Re: Sandia Peak Grid BESS Facility
7880 & 7850 Jacs Lane NE
Traffic Circulation Layout
Engineer's Stamp 03-07-2022 (D16-D002A9)

Based upon the information provided in your submittal received 03-23-2022 and field inspection (03-23-2022), the above referenced plan cannot be approved for Building Permit until the following comments are addressed:

| | A | ISSUED FOR PERMITTING | | | 02/11/2022 | JB | PPG | WKW | TH | | FOR 24x36 DWG ONLY | | TRAFFIC CIRCULATION PLAN | | | | | |

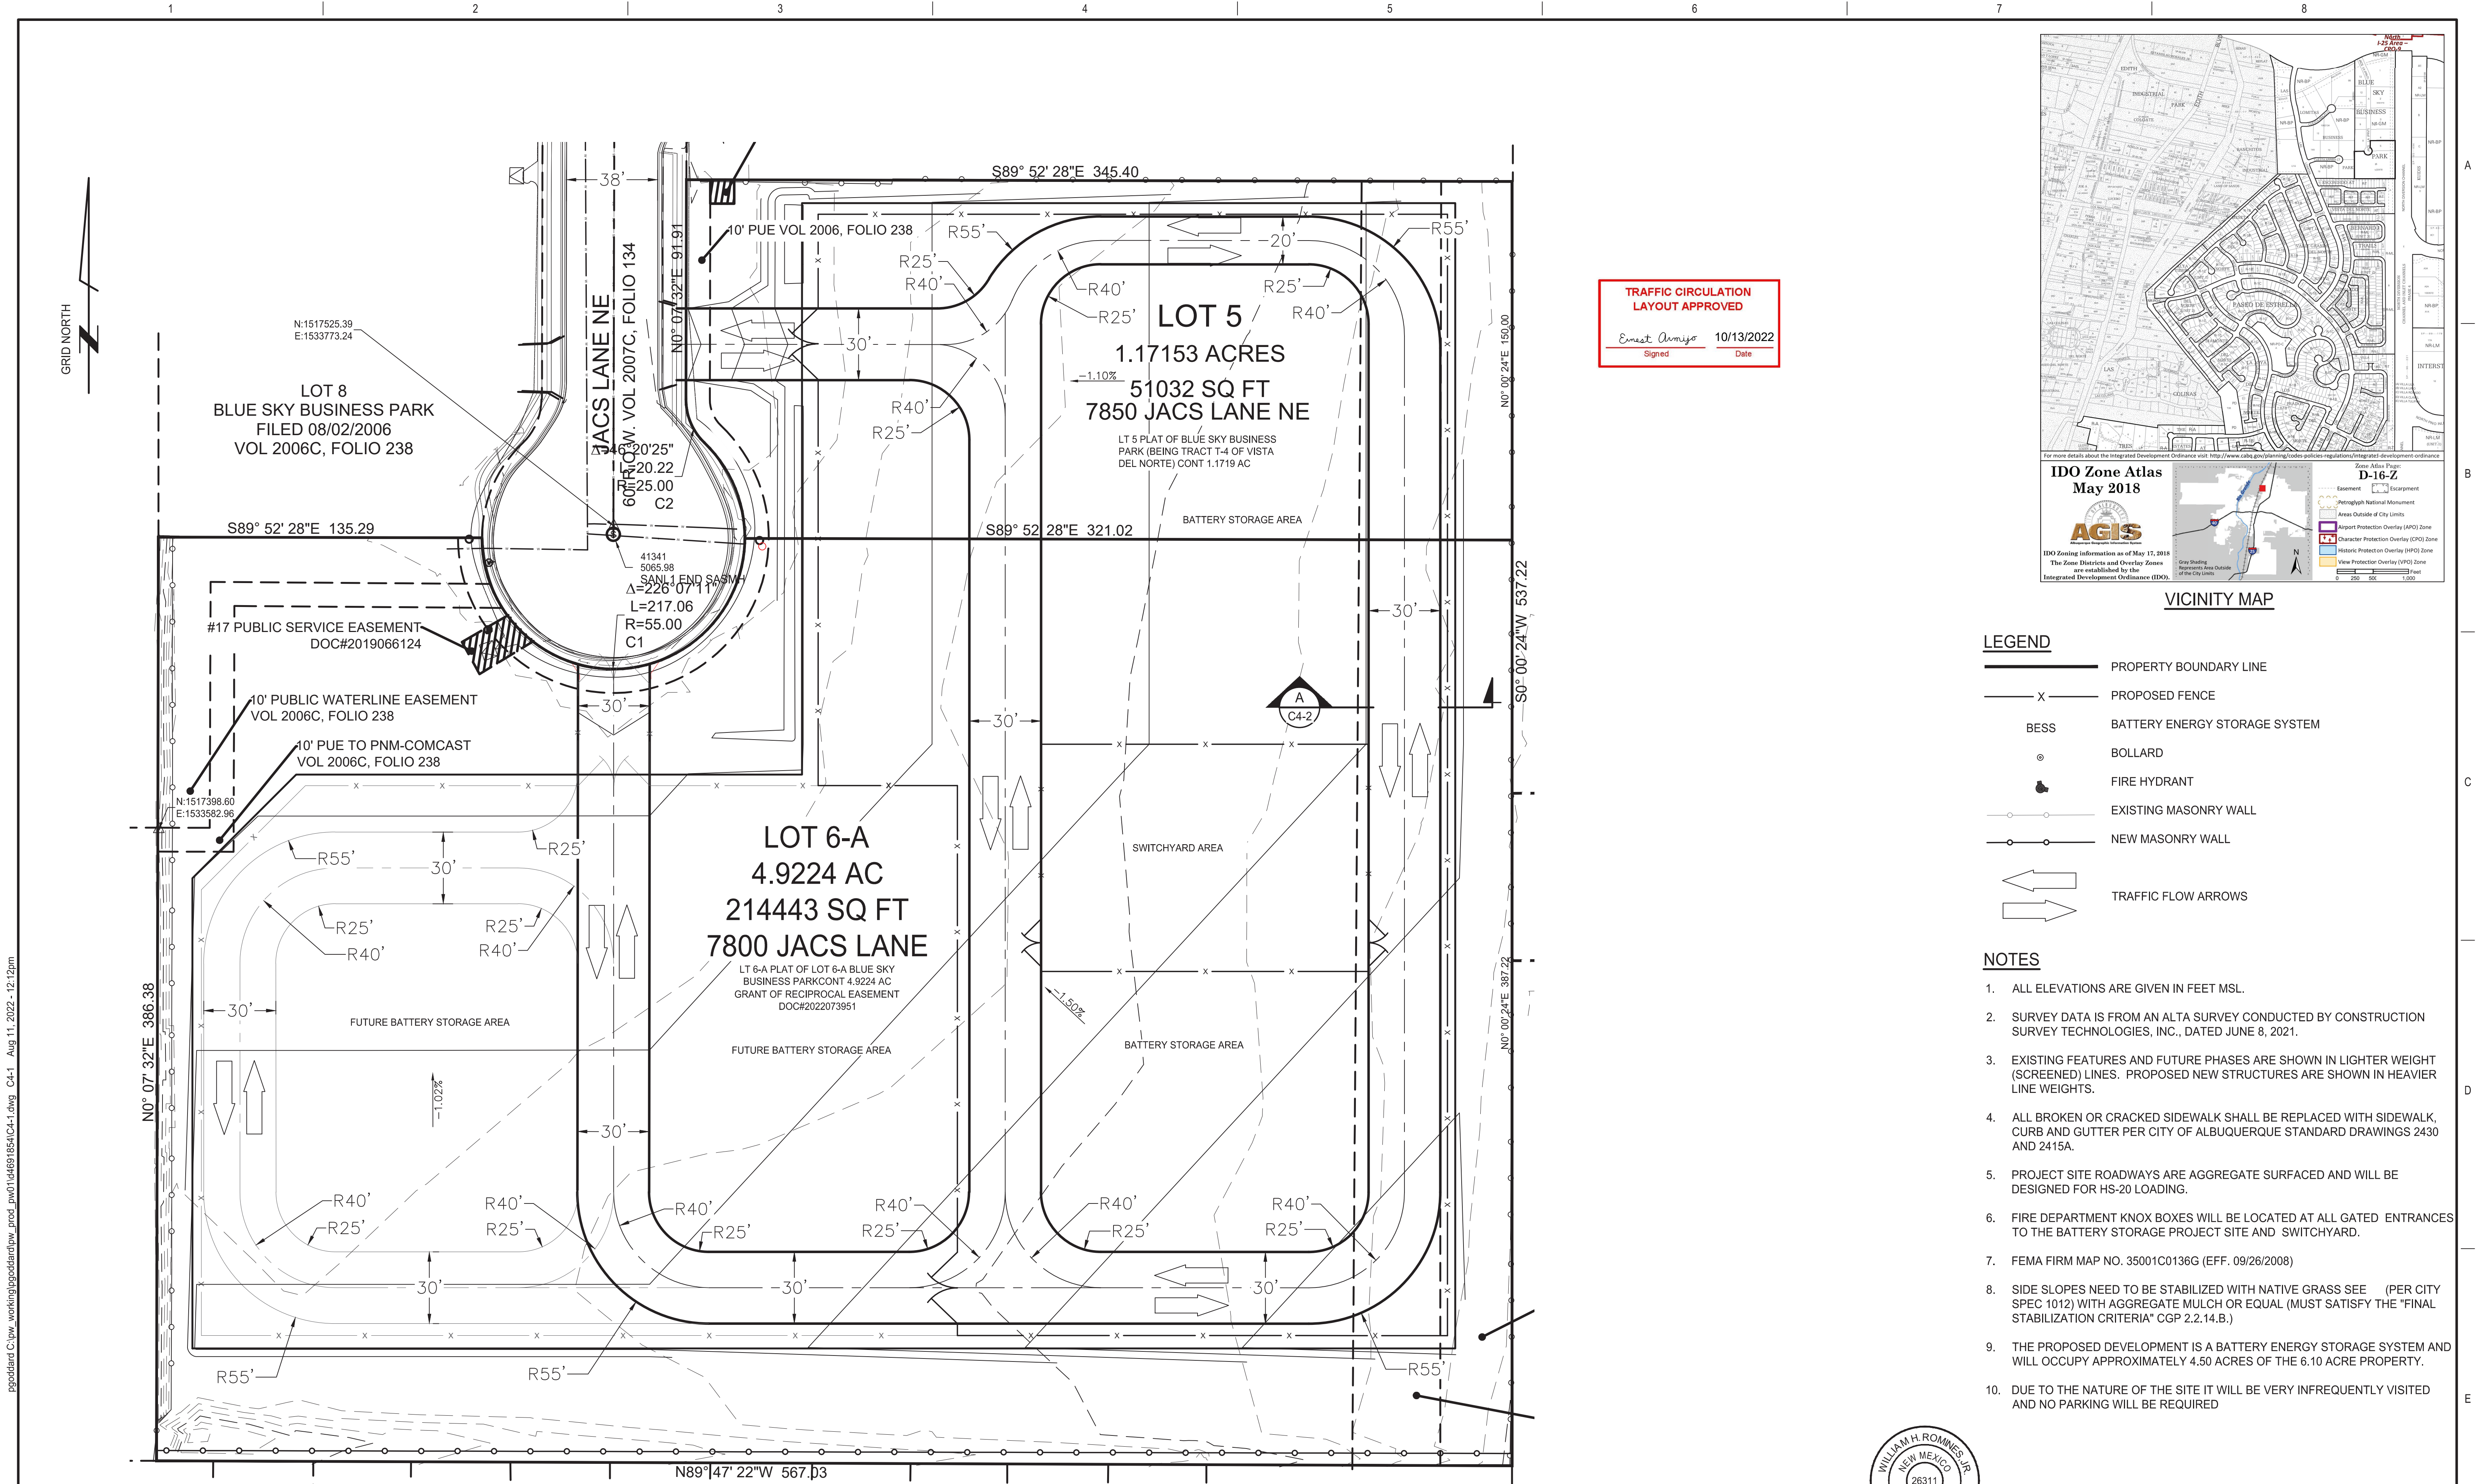
- WHAT IS THE STATUS FOR PARKING REQUIREMENTS? PLEADSE ELABORATE:**
Need to listed the number of parking spaces required by the IDO as well as the proposed number of parking spaces including bicycle and motorcycle parking.
Coordinate/discuss with Zoning (IF APPLICABLE).
- Maximum access width for arterial, collector, and **local streets(JACS LANE)** are as follows:

- The minimum drive aisle dimensions are shown below **(YOU HAVE PROVIDED ONLY 20 FT WIDTH, PLEASE JUSTIFY).**

- List radii for all curves shown; for passenger vehicles. Radius for delivery trucks, fire trucks, etc. is 25 ft. or larger. **Your are missing center line radius on all turns.**
- Provide a copy of refuse approval **(IF APPLICABLE).**

6. Fire Department: An **approved** Fire 1 plan needs to be provided.
7. It is not apparent what type of pavement surface is being proposed. A hard driving surface will be required as part of this proposed project for drive aisles. **Please provide the pavement design to substantiate the required pavement surface.**

9. Add a note stating "All broken or cracked sidewalk must be replaced with sidewalk and curb & gutter." A build note must be provided referring to the appropriate City Standard drawing (2430 & 2415A).
